EPC STORMWATER REVIEW COMMENTS  
IN ORANGE BOXES WITH BLACK TEXT

Final Drainage Report  
for  
**Rolling Hills Ranch North Filing 2**  
at  
**Meridian Ranch**

**MERIDIAN RANCH**  
A GOLF & RECREATIONAL COMMUNITY

July 2024

FIGURE 6

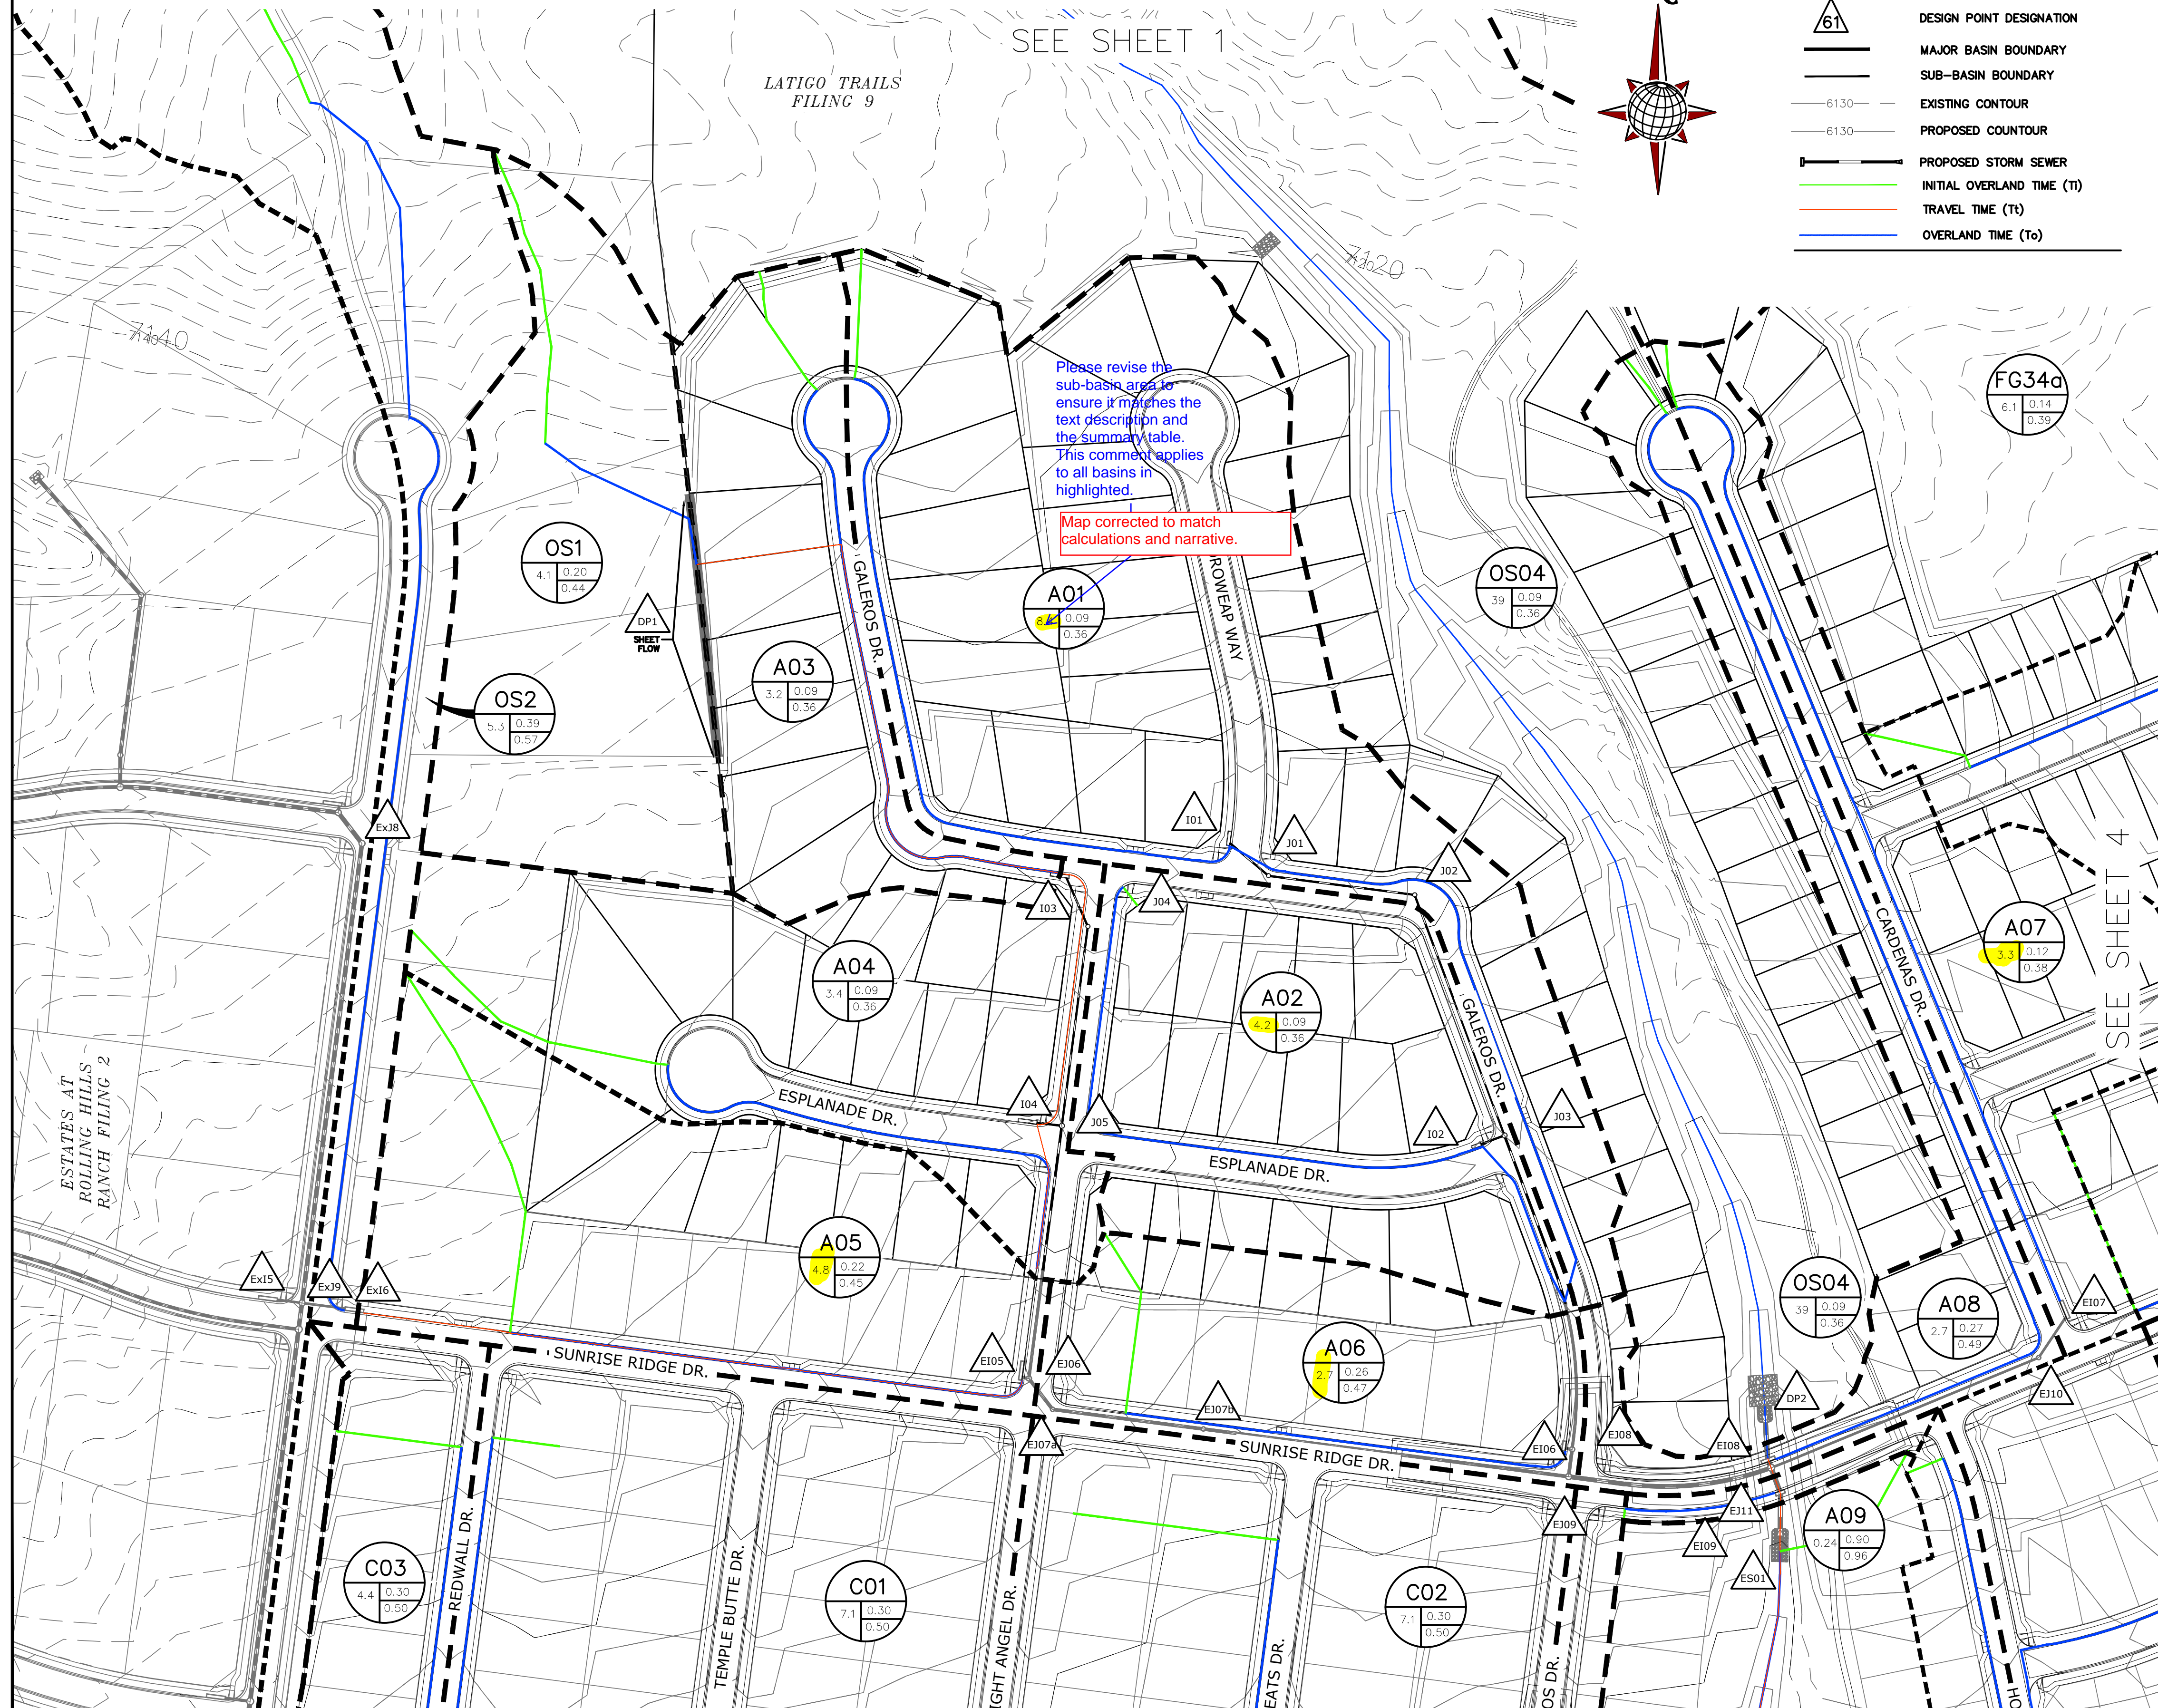
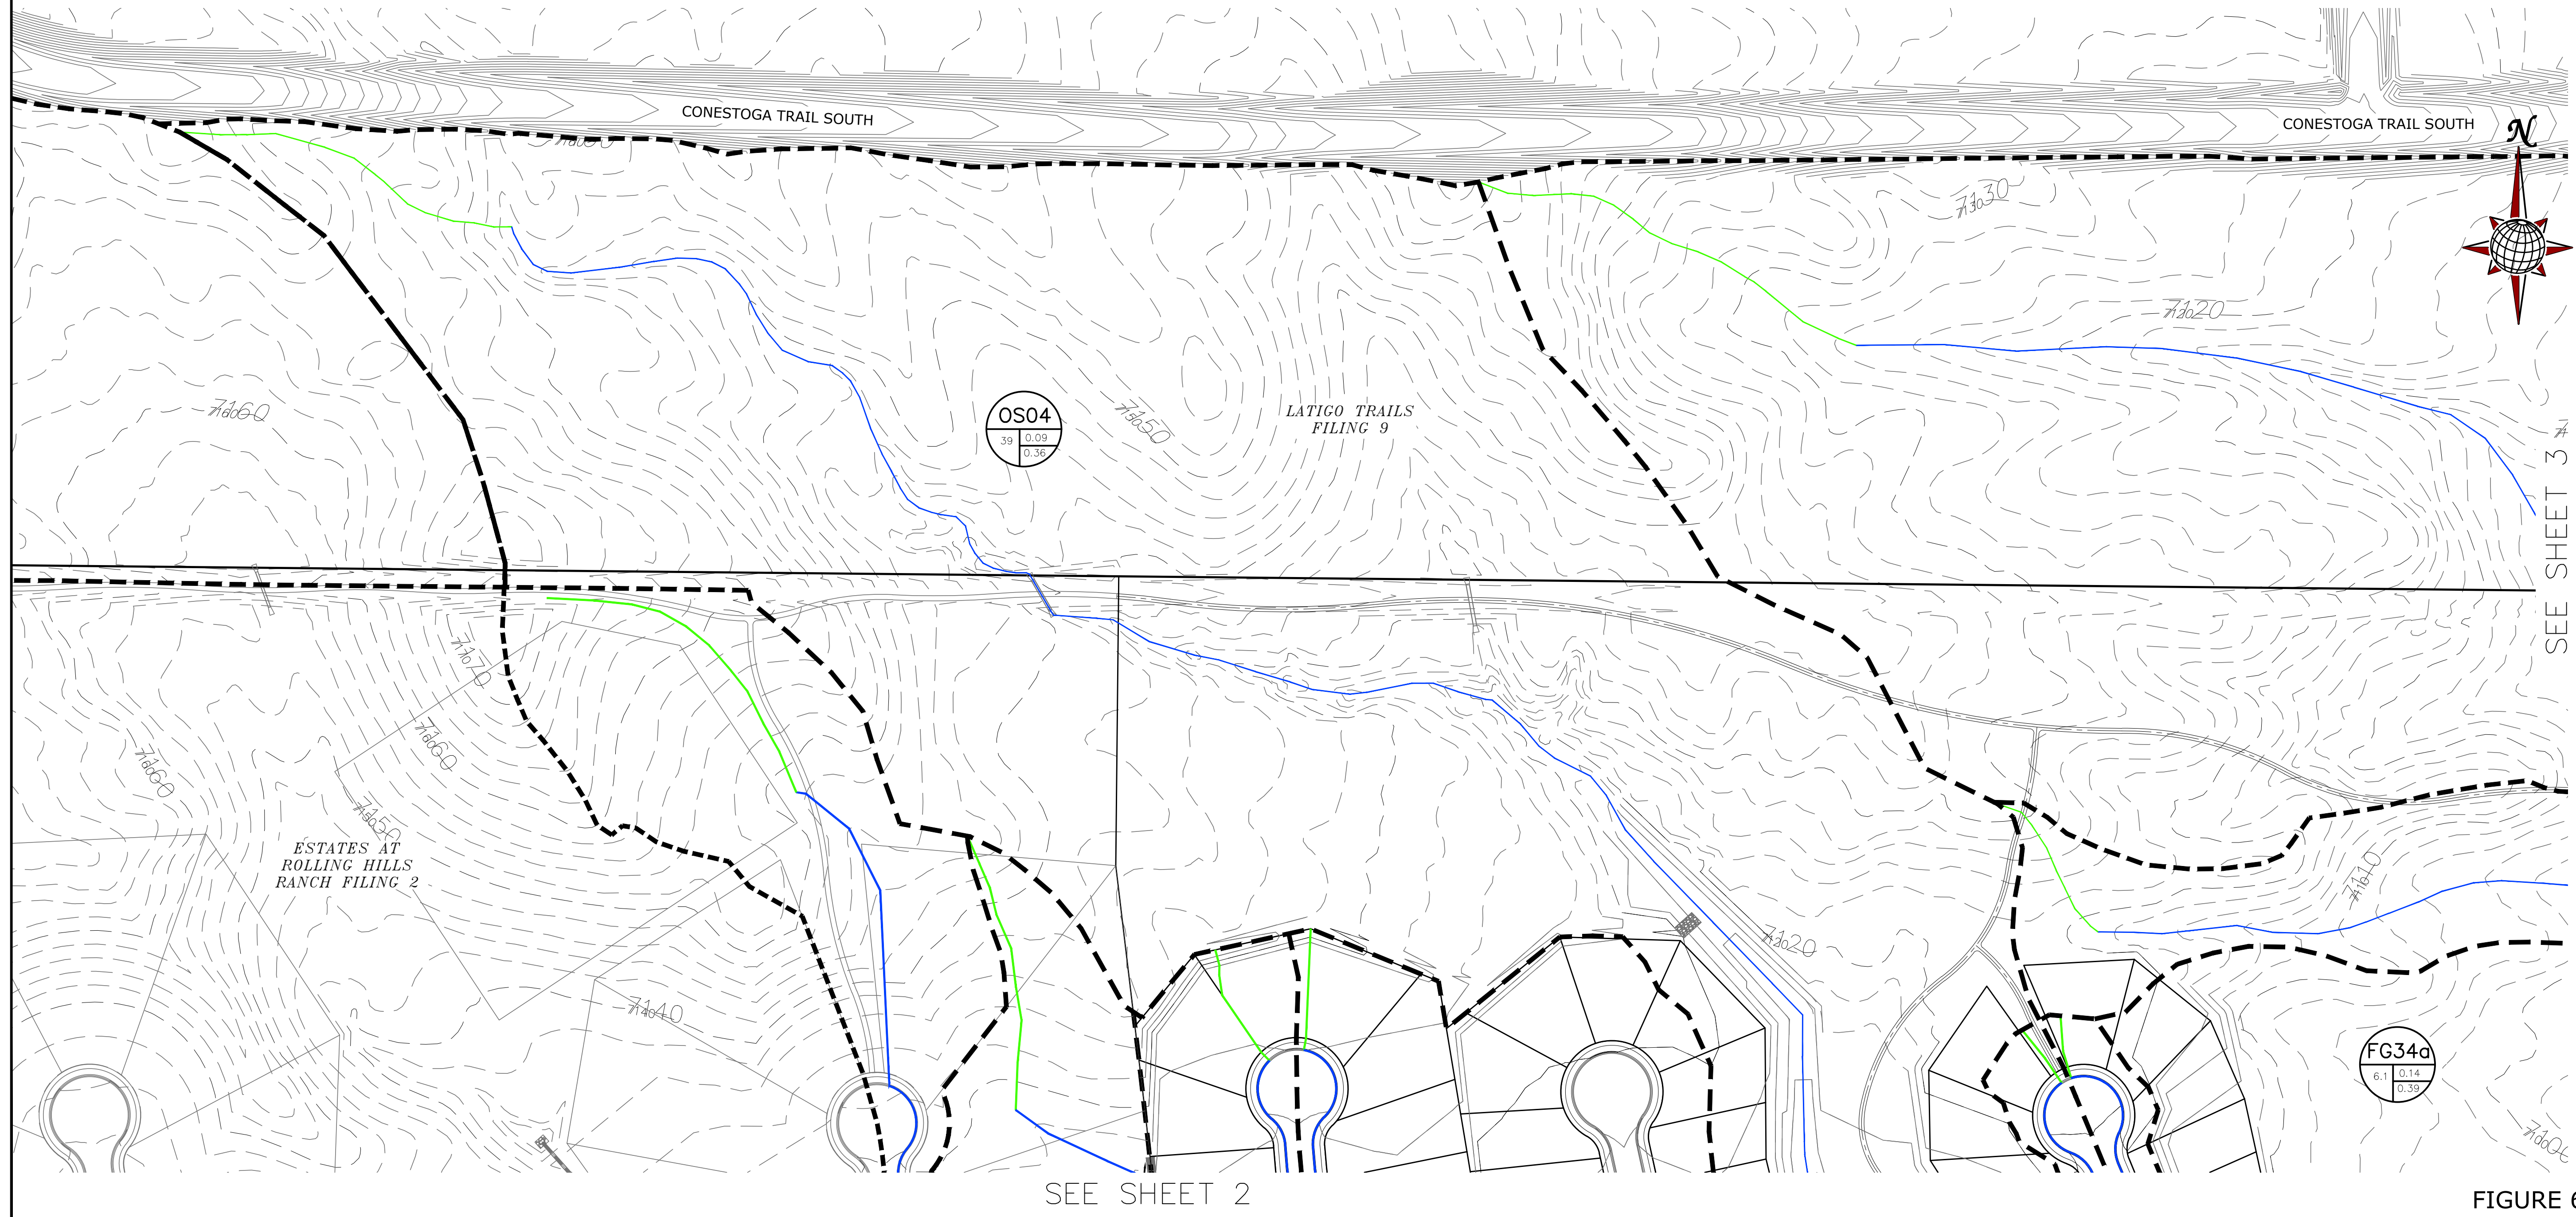
For all sump inlets, the emergency overflow path in the case that the inlet becomes fully clogged needs to be discussed.

Please mention the proposed 18" RCP and the existing RCP, as there are two sections of pipes in this area.

It appears there are existing storm pipes and inlets within the project area. Please assess their capacity to handle the proposed runoff and provide hydraulic calculations for an existing storm pipes and inlets.

Please revise the highlighted numbers to match the calculations and summary table.

Please revise all calculations for the highlighted numbers.  
These numbers do not match the summary table.
